PRE-DESIGN CONFERENCE RECAP

SUBJECT: Sandra Plaza/Juan Tabo
LEGAL DESCRIP.: Tract B2-A B/LK 76A Princess Jean
Add'n.

REF: DRAINAGE AND GRADING PLAN FOR SANDRA PLAZA (J21-D21) RECEIVED
MAY 7, 1985

RE: REVISED DRAINAGE AND GRADING PLAN FOR SANDRA PLAZA
(J-21/D21) RECEIVED JUNE 14, 1985

GRADING PLAN

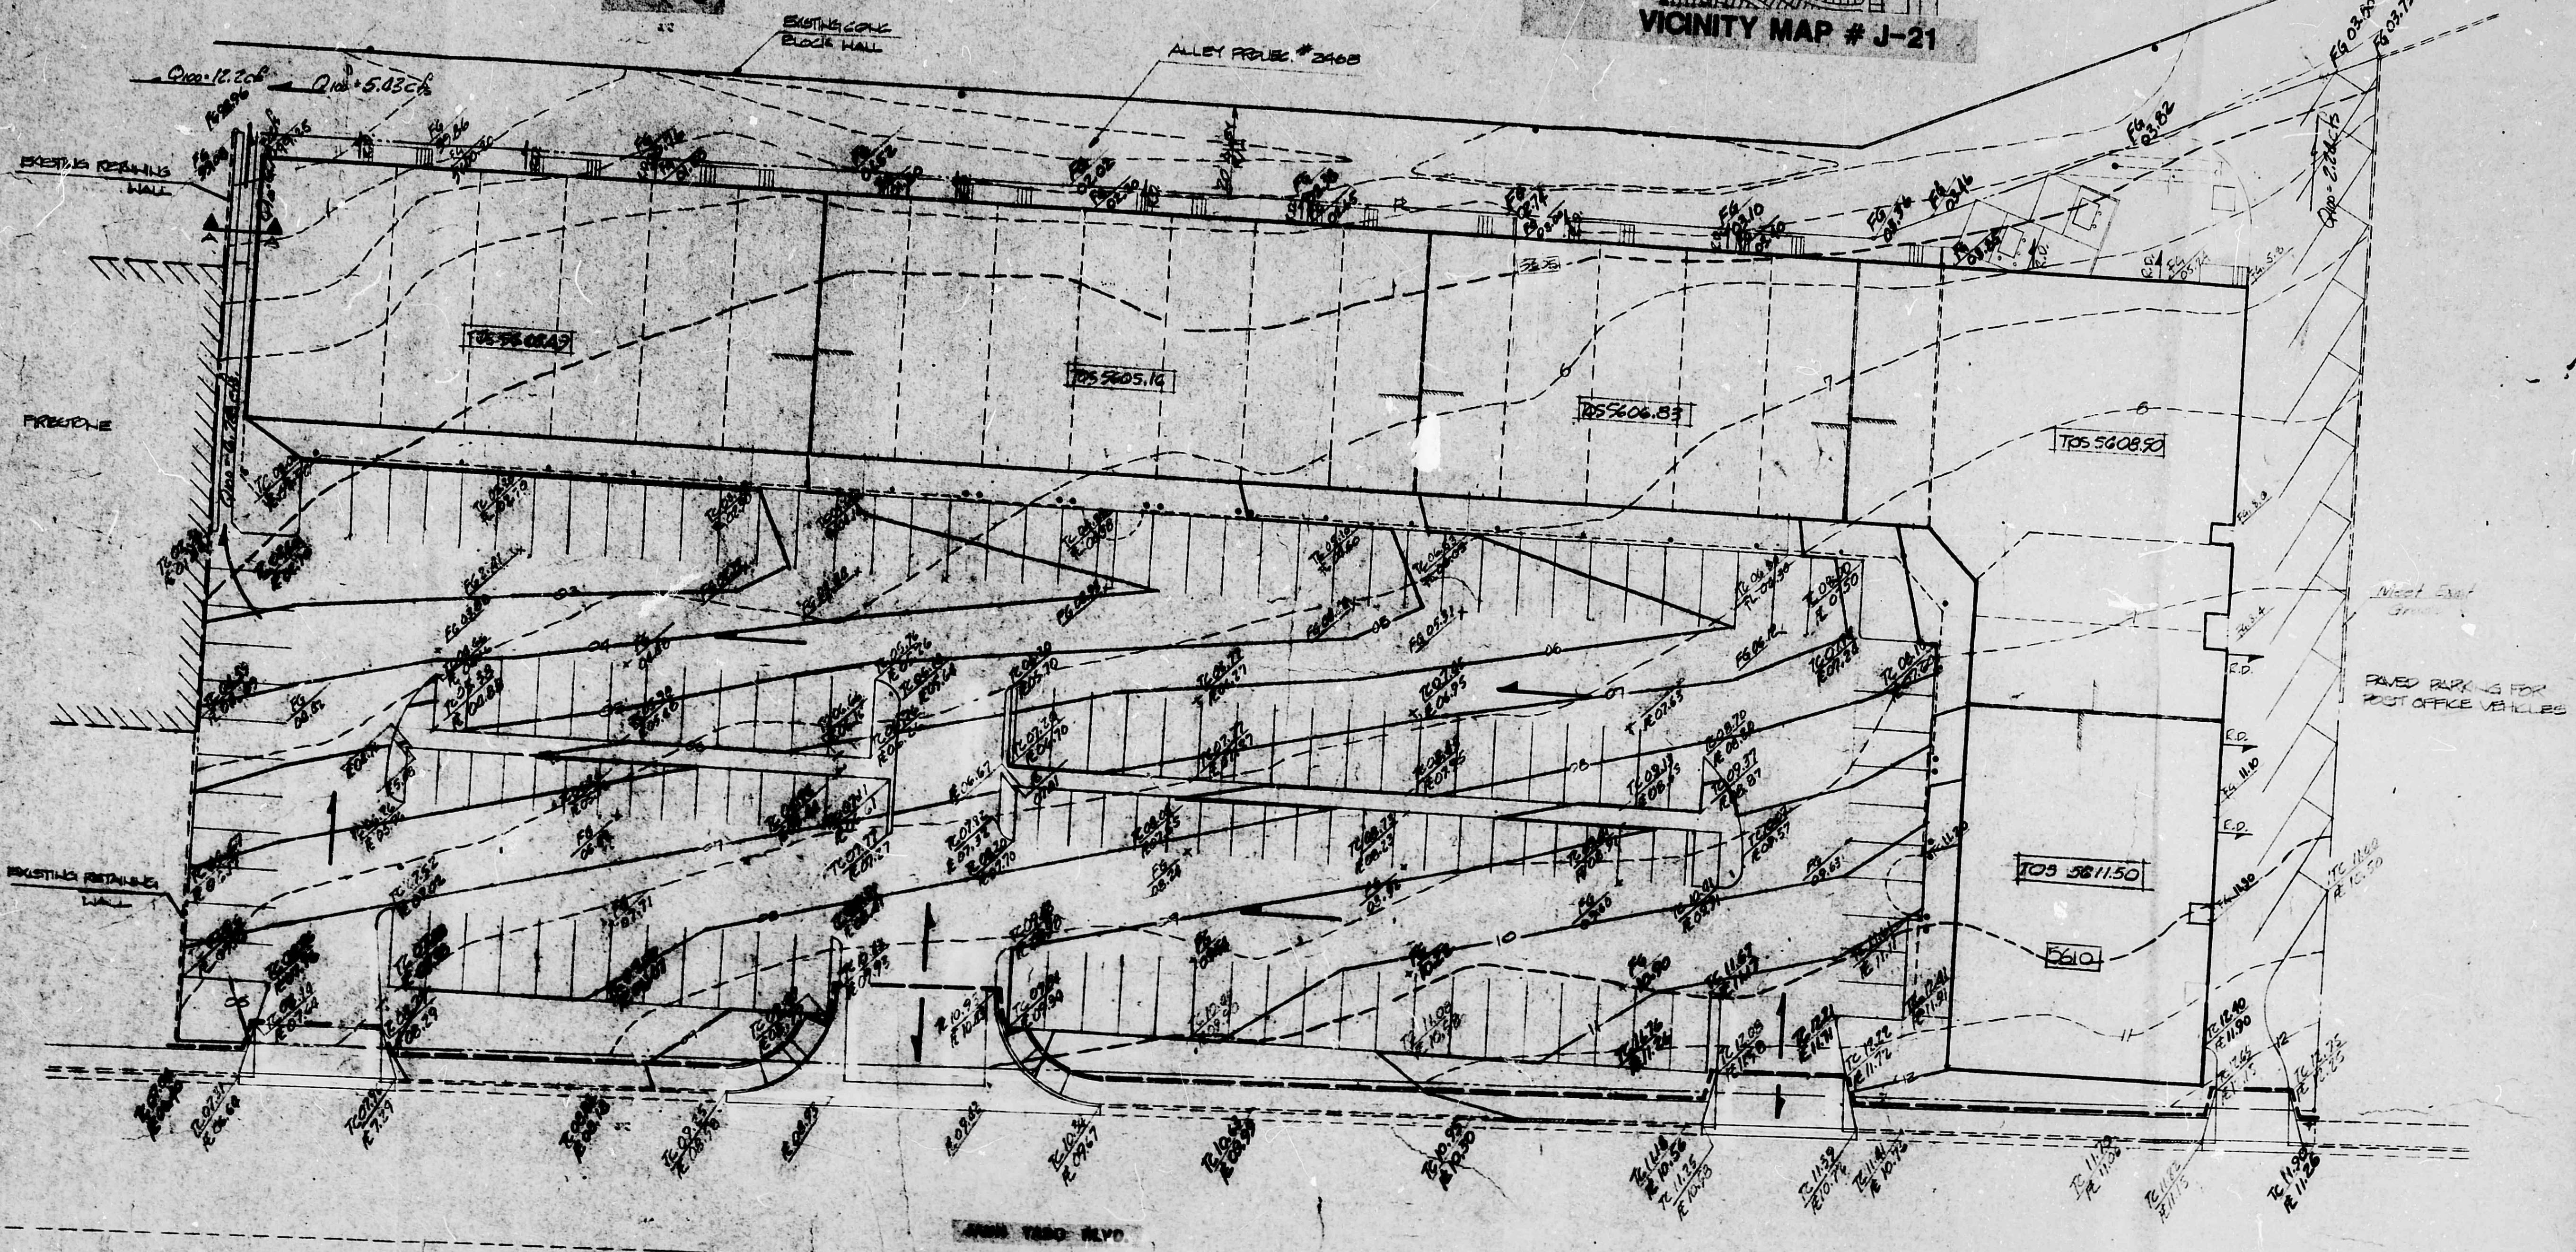
1. New information sheet with resubmittal designation.
2. Engineer's stamp with signature and revision date.
3. Please identify W.O. number for alley grades.
4. Legend indicating proposed and existing contours and all other pertinent information use DPM Volume 2, Table 27.3a-27.3d for recommended standard symbols (contours on plan do not indicate contour elevation, please address).
5. With the amount of flows developed, what impact will the discharge have into the alley through the proposed rundown. (How do you propose to turn the developed flows into the alley?)
6. Please indicate flow arrows within your master copy and not penciled in on a blue line print.
7. Please indicate what is existing to the north of proposed development.

8. Please indicate that the identified City BM will also act as the TBI for the project.

1. New information sheet with resubmittal designation.
2. Engineer's stamp with signature and revision date.
3. Floor pads to full mean sea level designation.
4. Please identify the location, direction and quantification of each drainage basin.
5. Alley will need to be paved (developed runoff generated to existing alley, erosion protection required by means of pavement).

We have revised and corrected the grading plan for the Sandra Plaza project in accordance with your letter of 28 May 1985.

The flows from the rundown into the alley will be turned by an existing block wall that extends the entire length of the alley along the west line of the alley right-of-way.

Enclosed is revised grading plan for the proposed Sandra Plaza Retail Center. I believe I have made the required revisions.

The developer for Sandra Plaza has received approved alley grades and is now in the process of obtaining a license to pave the alley from his north property line south to Princess Jeanne Avenue. This is project 2468.
